Application for Removal or Variation of a Condition following Grant of Planning Permission or Listed Building Consent

DEMOLITION OF EXISTING GARAGE AND ERECTION OF SINGLE STOREY SIDE EXTENSION AND LINK

2022/62/90403/E

Client: LUMB		
Project: 5 HOPTON HALL LANE		
Drawing Title: GA PLANS - GROUND & FIRST FLOOR		
Stage: Planning	Status: S0	
Drawn By: JL	Date: April 21	Scale: As Noted
Job Number: 2005	Client Project Number: n/a	Sheet Size: A1
2005-004		Revision: P04

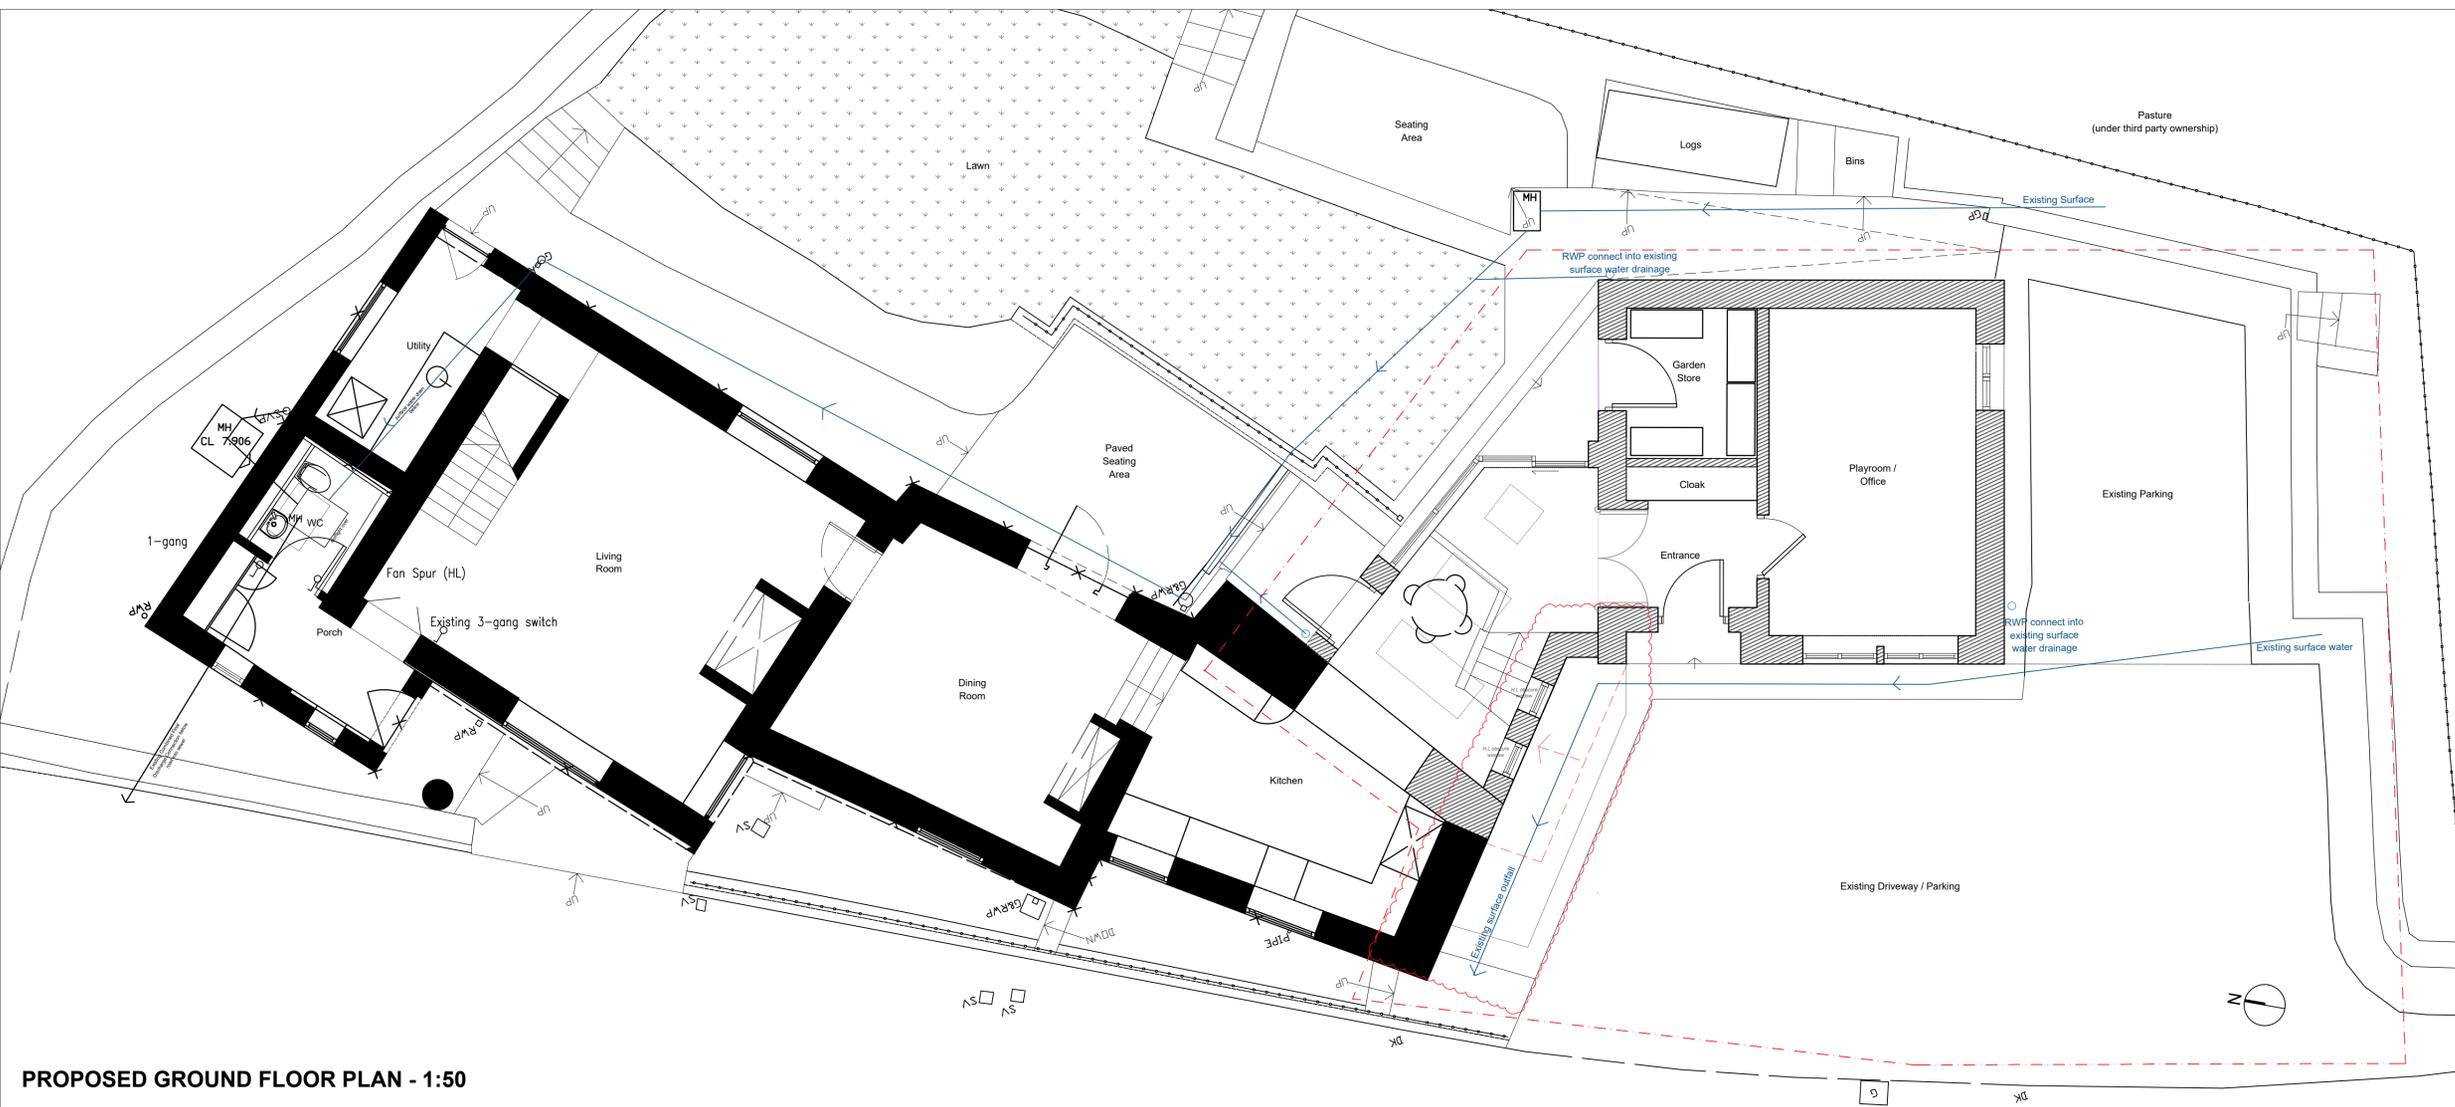
Item 1 - We would like to slightly reduce the footprint/volume of the proposed development.

Item 1 - To avoid existing surface water drainage routes (as identified on the attached plan). The elevations remain as proposed, with a minor adjustment to a wall position of the linking extension.

202005_004_Ground and First Floor_P04
